DEVELOPMENT REVIEW BOARD  
SUPPLEMENTAL SUBMITTAL

PROJECT NO. 2018-001579

SUBMITTAL DESCRIPTION: Departmental comments indicated a number of items to be addressed in a deferred hearing date, indicated above for multi-family apartments project at 7500 Indian School Rd in the Winrock Town Center. Responses to the comments and revised sheets are provided.

This letter outlines the modifications that have been made to the Apartments at Pennsylvania St and Indian School Rd application for a major site plan amendment to the approved Winrock Town Center Site Development Plan (PR-2018-001579) to address the agency comments that were received.

DRAWN BY	D/P/S
REVIEWED BY	D/P/S
DATE	02.05.2021
PROJECT NO.	19-0087
DRAWING NAME	SITE PLAN

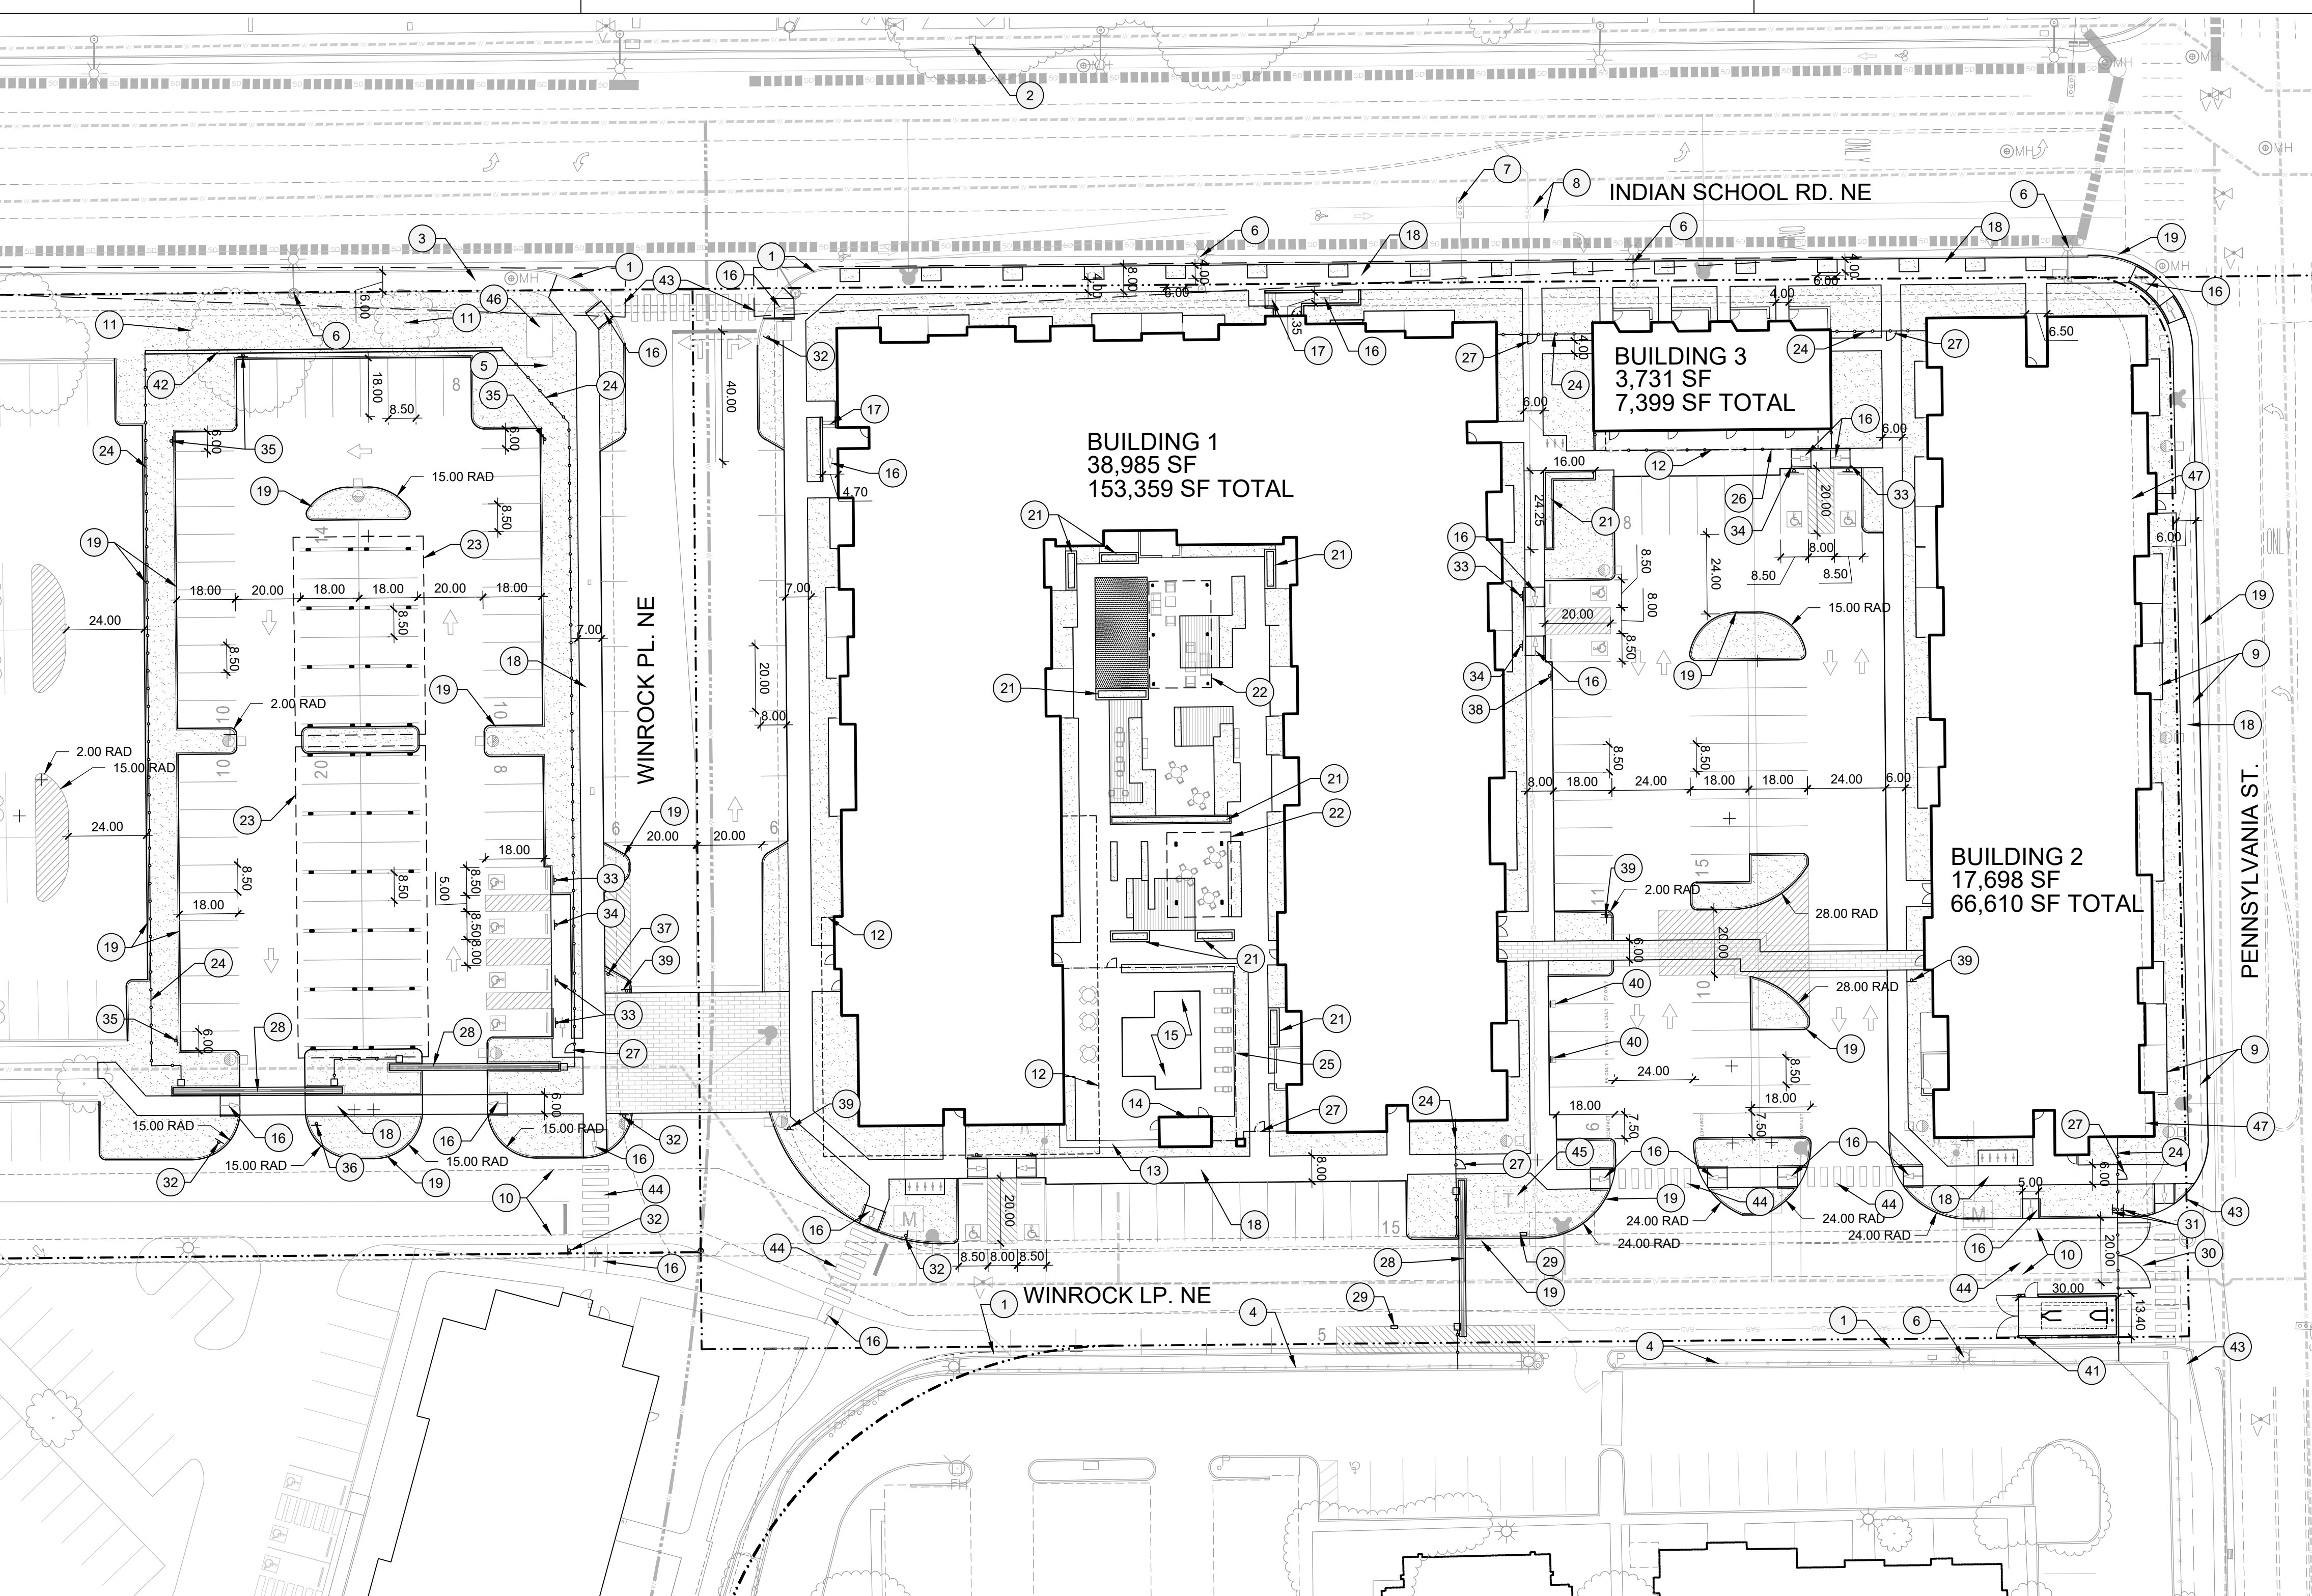
4. Clarify on the plan that public improvements shall be built per the work order drawings.

7. Update right-of-way lines and any new easements from the plat on the site plan.

- a. Availability statement #201105 has been issued and provides the conditions for service.
- b. Site Plan
  - i. Please provide documentation that the ABCWUA will have ability to access the gates (key note 28 and 30) for maintenance.

- ii. The proposed trash compactor (keyed note #41) cannot encroach into the public waterline. Please relocate.

*Site plan has been updated to include a note "Public improvements shall be built per separate work order drawings."*

*Site plan has been updated to include new public sidewalk easement and new ABCWUA sanitary sewer easement.*

*Access will be provided to the Fire Department, ABCWUA, and Solid Waste via fob access/keyed entry. Gate at Pennsylvania (keyed note 30) is an emergency exit only gate.*

*Trash compactor is at least 6-feet clear of the existing public waterline. Application grants additional ABCWUA waterline easement to the north.*

**CONCEPTUAL UTILITY PLAN**

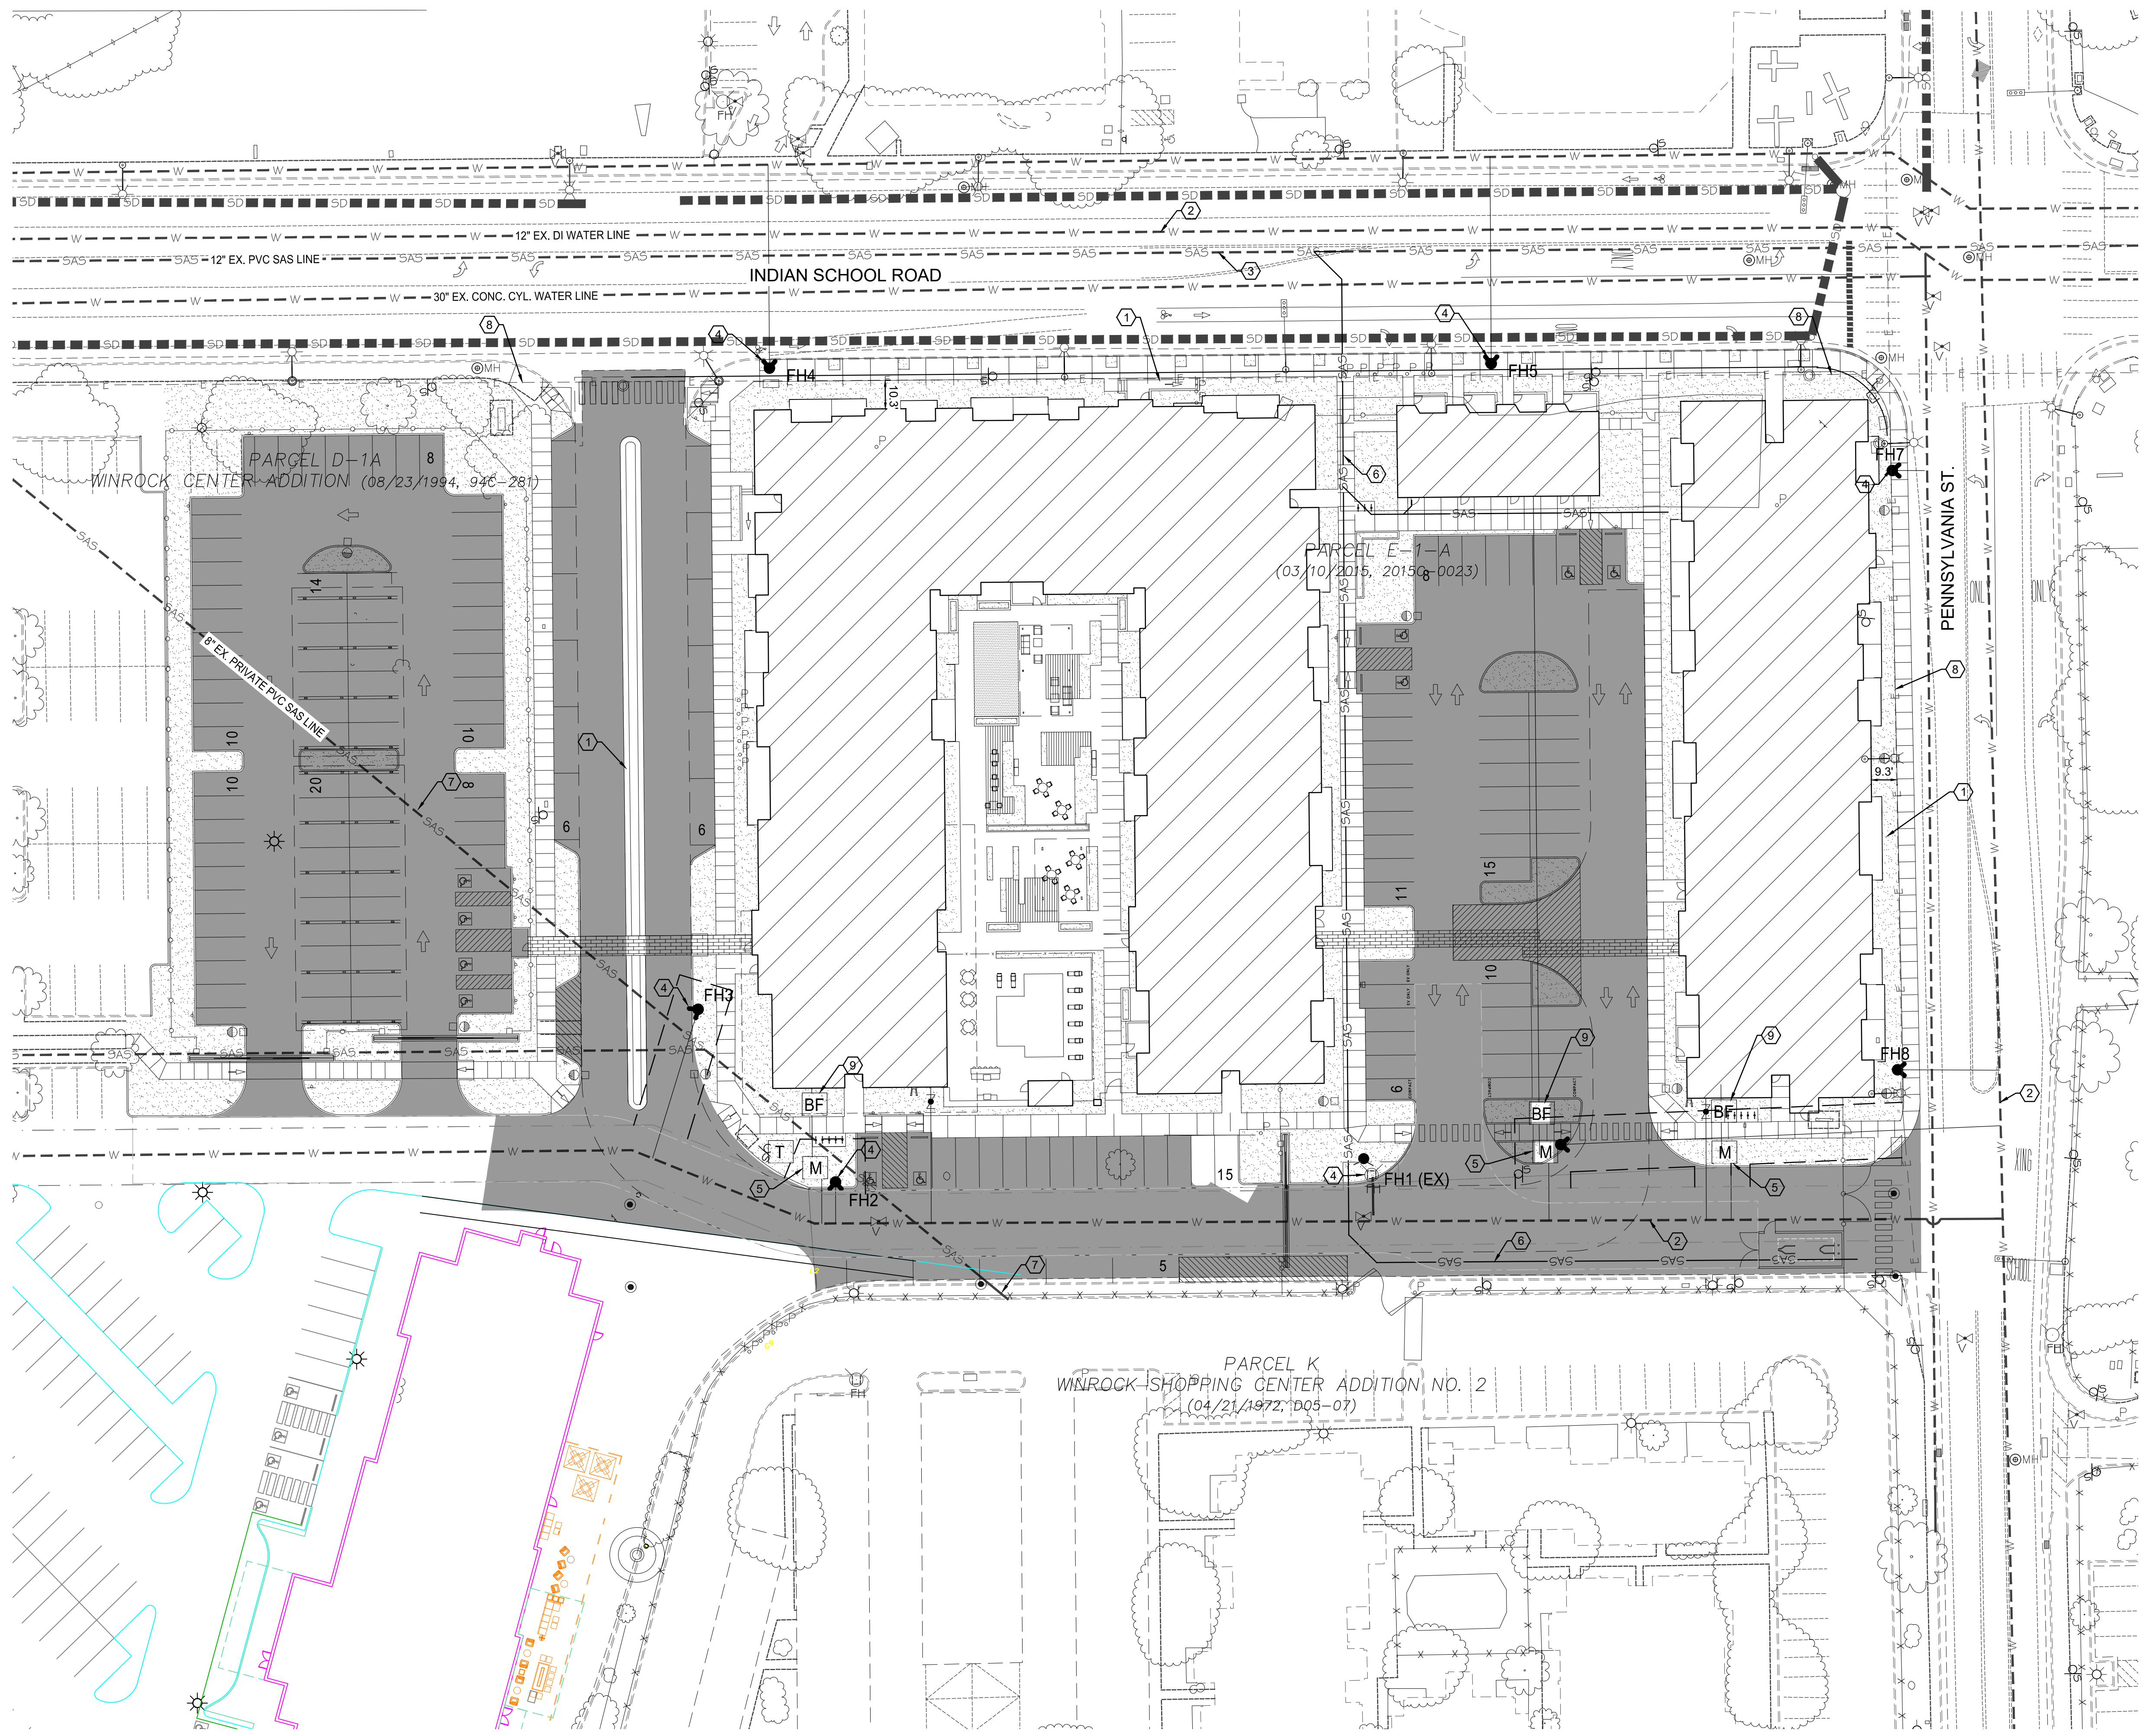
- ii. Please indicate if the Keyed Note #6 sanitary yard line has any connections from Parcel K. If so, the public sanitary sewer (Keyed Note 11) shall be extended so that Parcel K can connect to the public sanitary sewer.

- iii. PREVIOUS COMMENT: All proposed fire hydrants onsite shall be labeled as private. Fire hydrants in public right-of-way shall be labeled as public. The response to comments concurred, however FH#3 and FH#2 are labeled as public fire hydrants. Please label as private. FH#6 is not labeled and shall be private. FH#8 is not labeled and shall be public.

- iv. PREVIOUS COMMENT: Demonstrate a private easement for the private fire hydrant #3, given that the waterline being connected to is on another parcel. Alternatively you may show this waterline connecting to the public main on Tract E-1-A.

- vi. Keyed note #6 and #7 point to the same private sanitary sewer, however one is existing and the other is proposed. Please confirm the termination of the existing private sanitary sewer. Please label the sanitary sewer as being private.

*Utility plans have been updated.*

*Utility plans have been updated.*

*Utility plans have been updated.*

*Utility plans have been updated.*
